DEVELOPMENT HEARING OFFICER

PR-2022-007299

SD-2024-00113 – PRELIMINARY/FINAL

CSI - CARTESIAN SURVEYS INC. agent for BRUNACINI DEVELOPMENT requests the aforementioned action(s) for all or a portion of: TRACT I, TRACTS 54 & 55, COORS PLAZA; TOWN OF ATRISCO GRANT zoned NR-C, located at 7226 CENTRAL AVE SW between AMANDA ST SW and 7TH ST SW containing approximately 13.2493 acre(s). (K-10) [Deferred from 6/26/24]

DATE	AUGUST 9, 2024
NORTH	SCALE
	1"=60'-0" OR AS NOTED
DRAWING NAME	SITE DEVELOPMENT PLAN
SHEET NUMBER	SDP-1

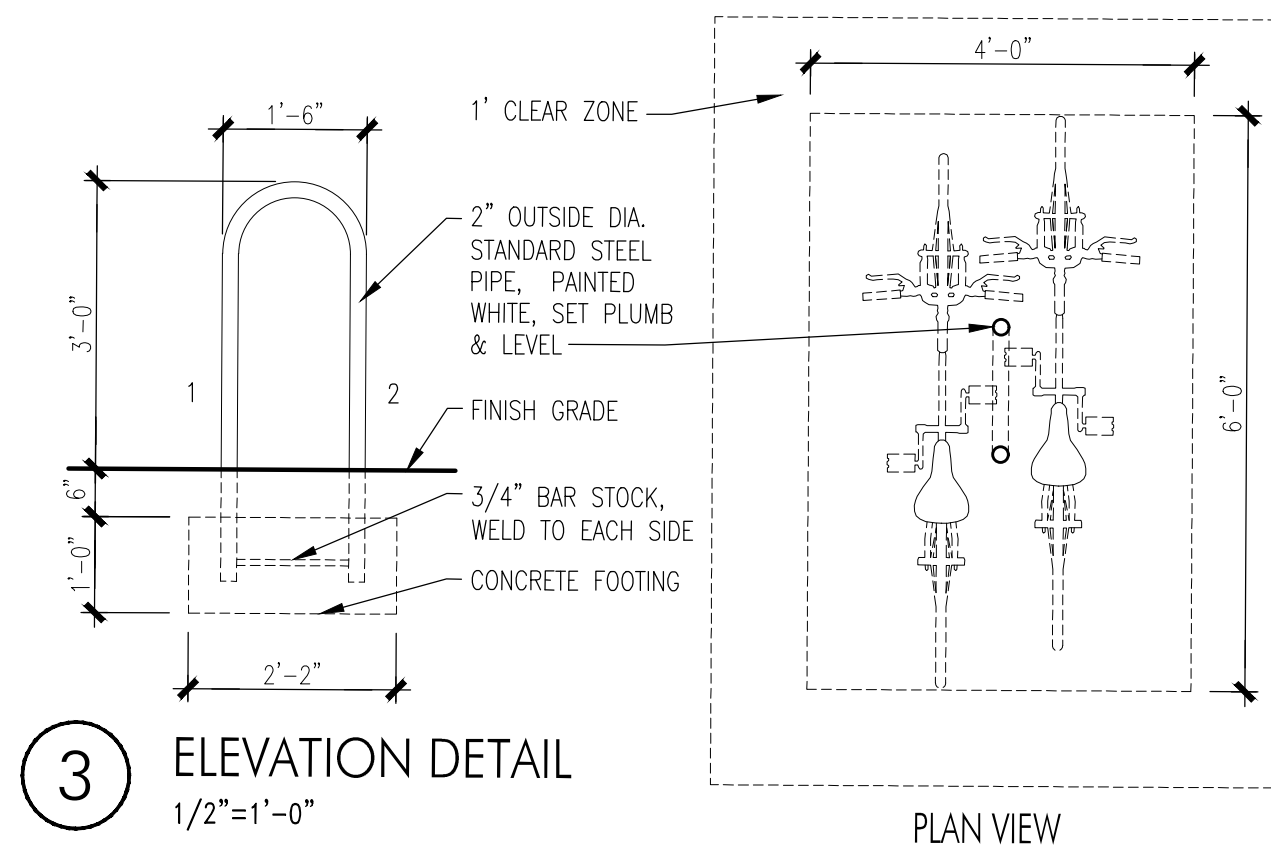
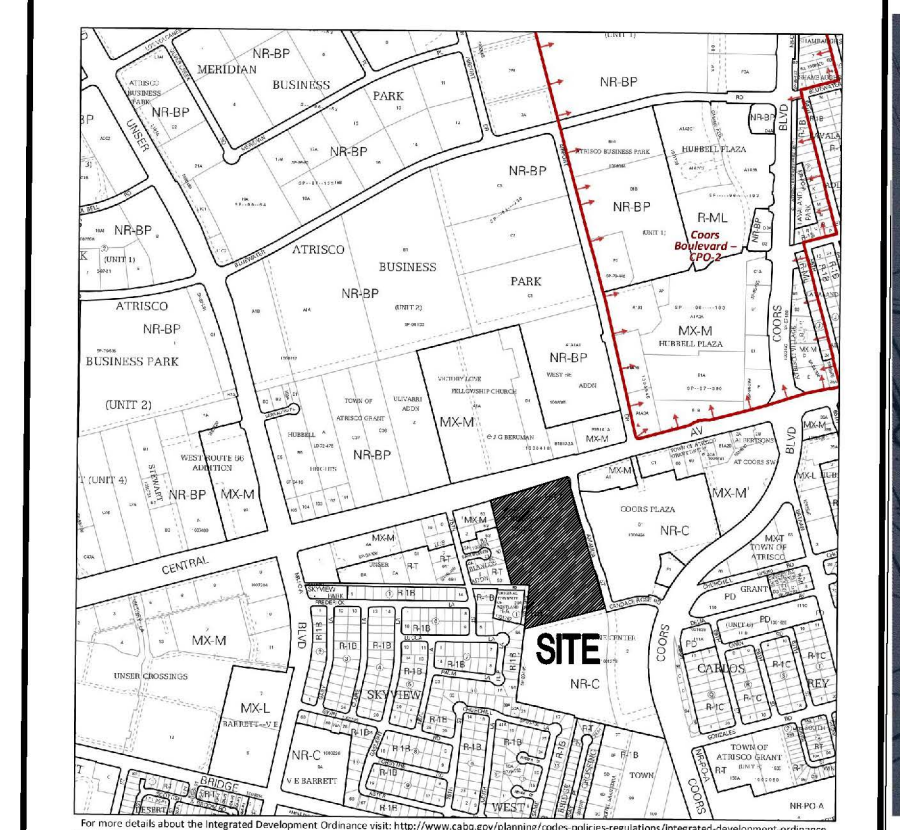
- 2. Fencing must be reviewed and approved via separate submittal for Fence Permit, and must meet requirements of IDO 5-7, Table 5-7-1. In NR-C zone, if setback 5 feet and view fencing above 3 ft, can do up to 6 ft high, per IDO 5-7(D)(3)(d).*

- 3. Must meet all Landscaping requirements as per IDO 5-6, including the following key items:*
 - a. Parking lot Landscape Buffer: as per IDO 5-6(F)(1)(i), the front lot edge must provide a landscape buffer if less than 30 feet from the front lot line. This buffer must meet requirements to screen headlights, using wall or vegetative screen.*

- b. Landscape Buffer: A 15 foot landscape buffer is required on west side where adjacent to the R-T zone, per IDO 5-6(E), Table 5-6-4.*
- 4. Signage must be reviewed and approved via separate submittal for Sign Permit, not through DFT. Must meet requirements of IDO 5-12, Table 5-12-2. However, the calculations shown for percent of façade appear incorrect. Each unit would only include the specific façade area for their business for percent calculations, and this shows entire combined façade and combined sign areas for multiple units.*

1. Central is a Principal Arterial within a center and requires 10' sidewalk with a 6' to 8' landscape buffer. Amanda St. is a local road and requires 5' sidewalk and a 4' to 6' landscape buffer. All sidewalks must have a 4-foot ADA pathway around all obstructions within right-of-way. ROW appears to be adequate along both roadways.
2. All work within the ROW shall be done under a work order and all infrastructure items placed on an infrastructure list.
3. For any future development, a Traffic Circulation Layout will be required prior to Building Permit or Site Plan for Building Permit.

Plat for Tracts I-1 and I-2, Coors Plaza Being Comprised of Remaining Portions of Tract I, Coors Plaza, and Tracts 54 and 55, Unit 6, Town of Atrisco Grant City of Albuquerque Bernalillo County, New Mexico May 2023

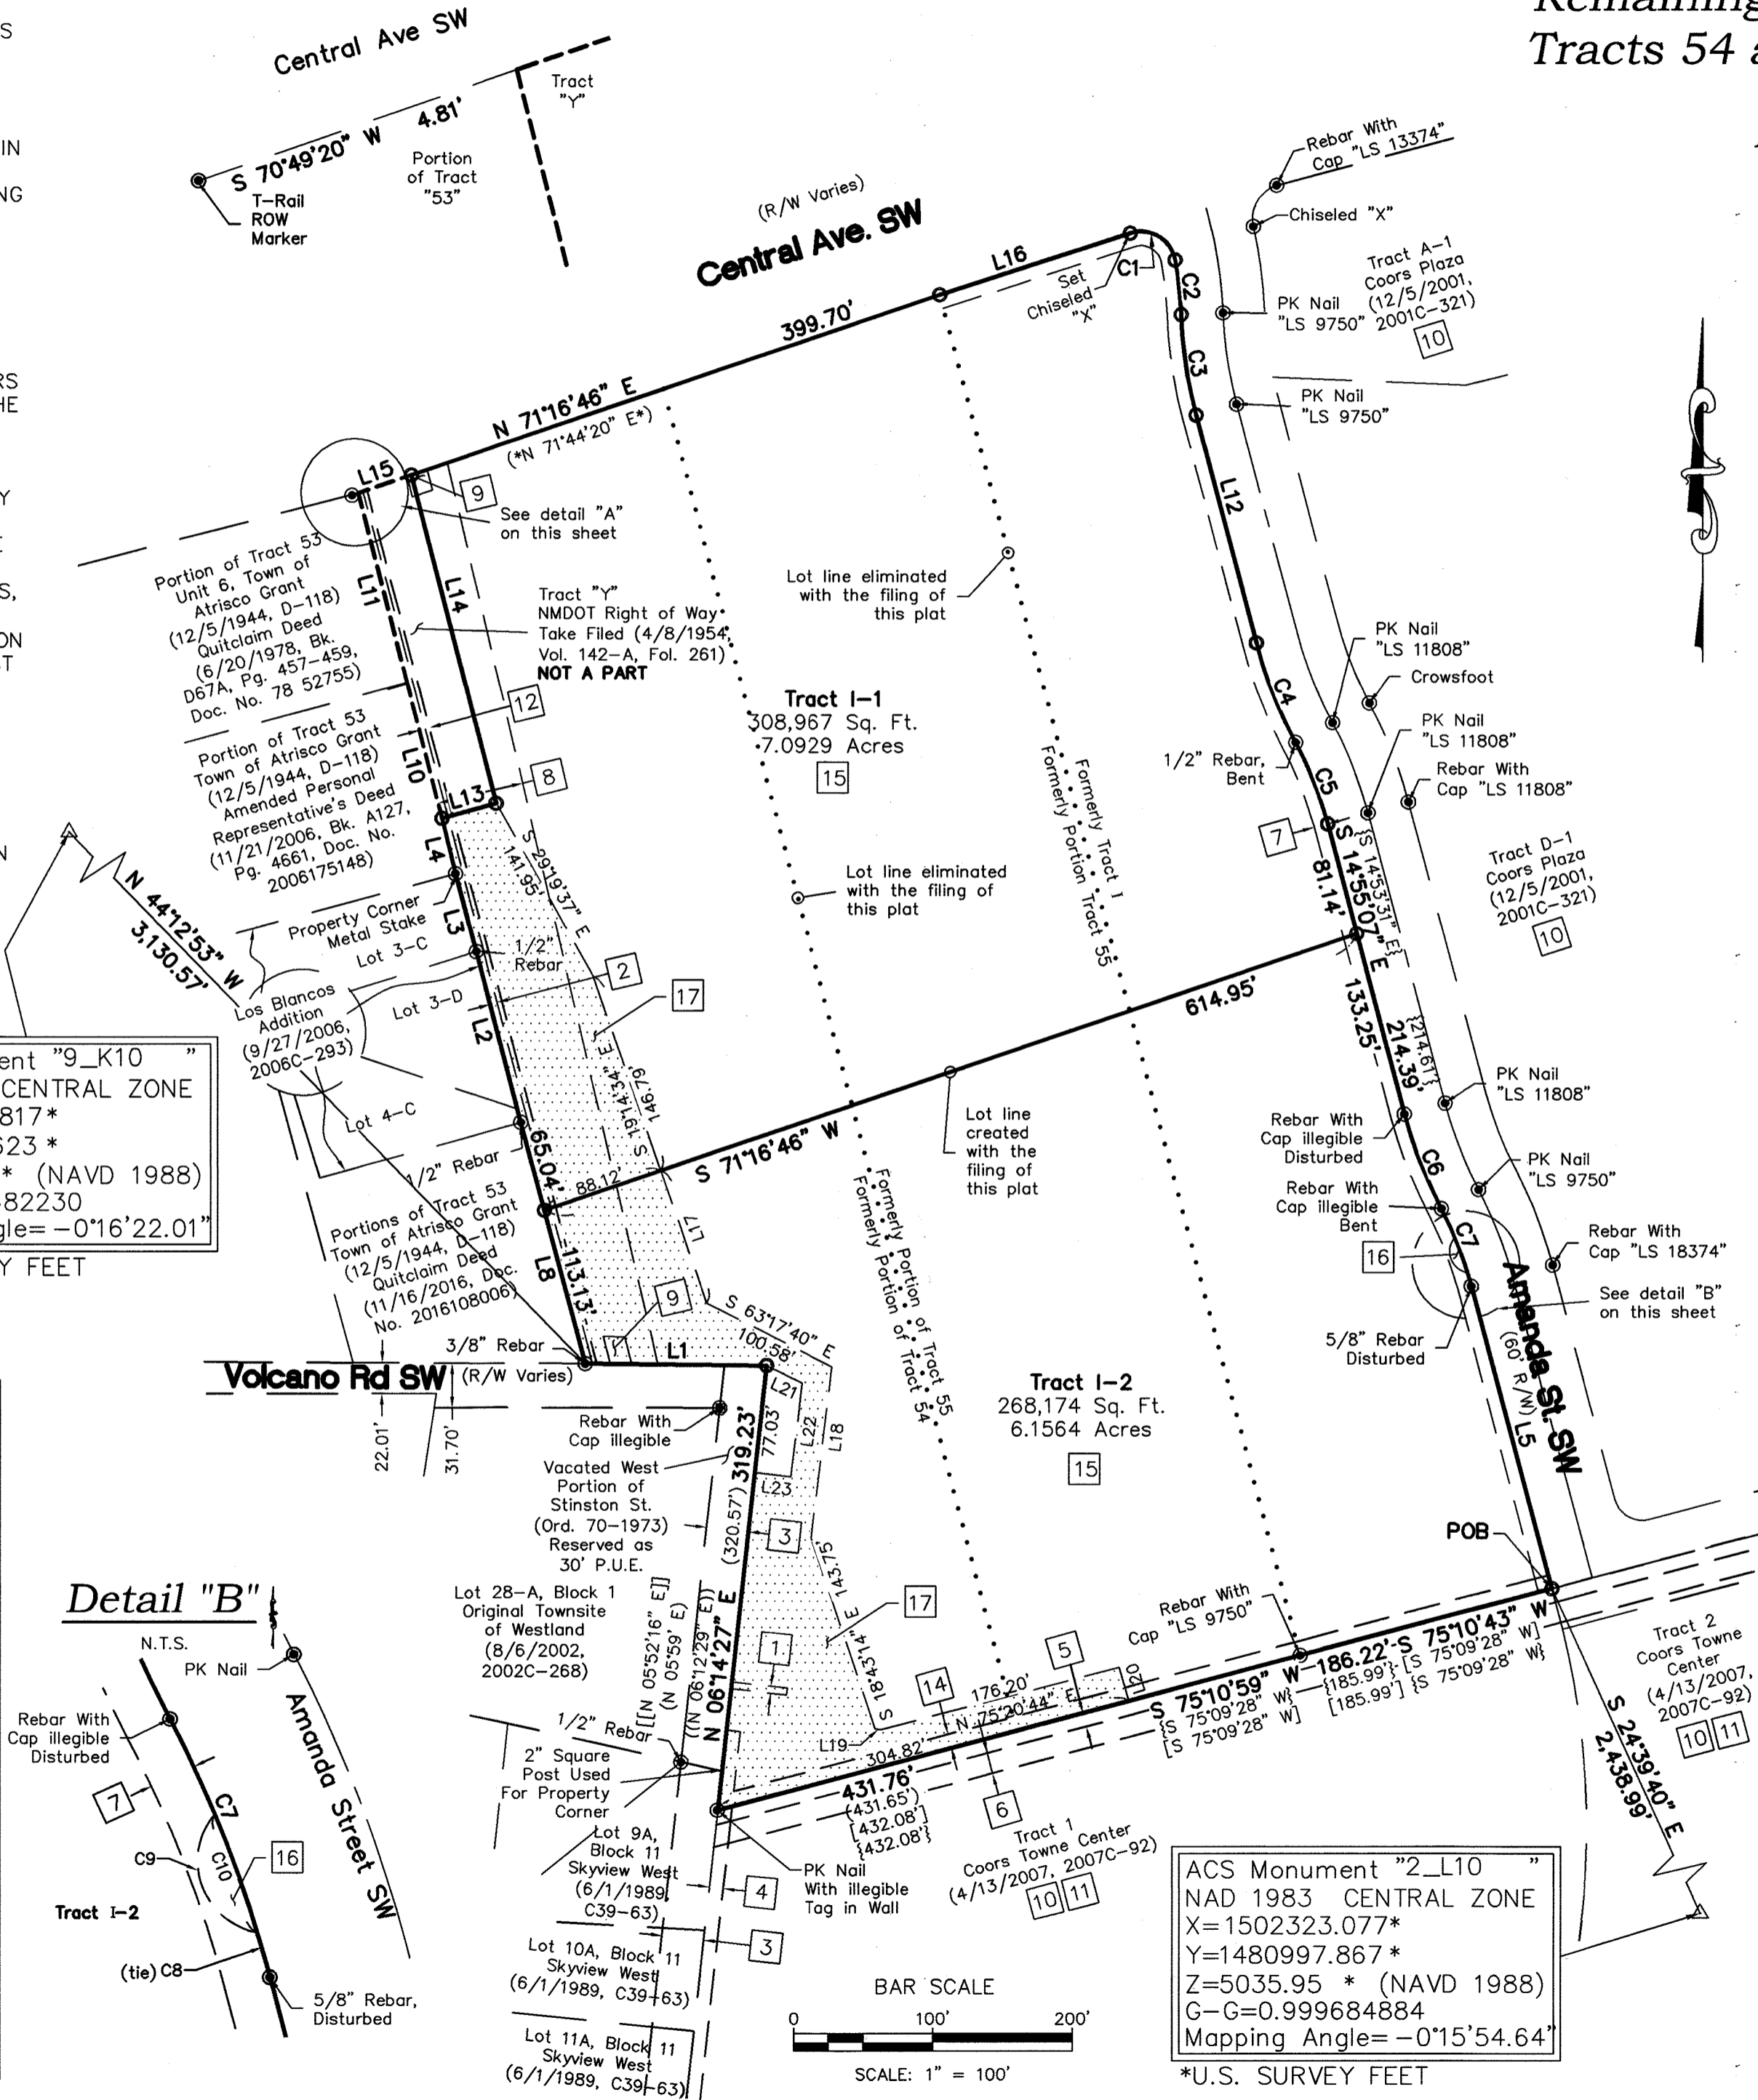
- Hydrology has an approved Conceptual Grading & Drainage Plan (K10D070) with engineer's stamp 06/06/2024.
- Hydrology needs a Public Drainage Easement as shown since there is public drainage passing through this site.

- Please add the City's standard drainage easement language.
- Comment - Prior to submitting for Building Permit, a licensed New Mexico civil engineer will need to submit a Grading & Drainage Plan to Hydrology for review & approval if one of these conditions is met. (500 cy of grading, 1,000 sf of proposed building, or 10,000 sf of proposed paving).

- The submitted plat has signatures from over 12 months ago and appears to need new signatures. Please explain signature dates.
 - Clarify access/roadway details, and any need for vacations, easements, and/or dedications.

- The Project and Application numbers must be added to the plat before final sign-off of the Plat.
 - A copy of the AGIS-approved DXF file must be submitted prior to the final sign-off of the Plat.
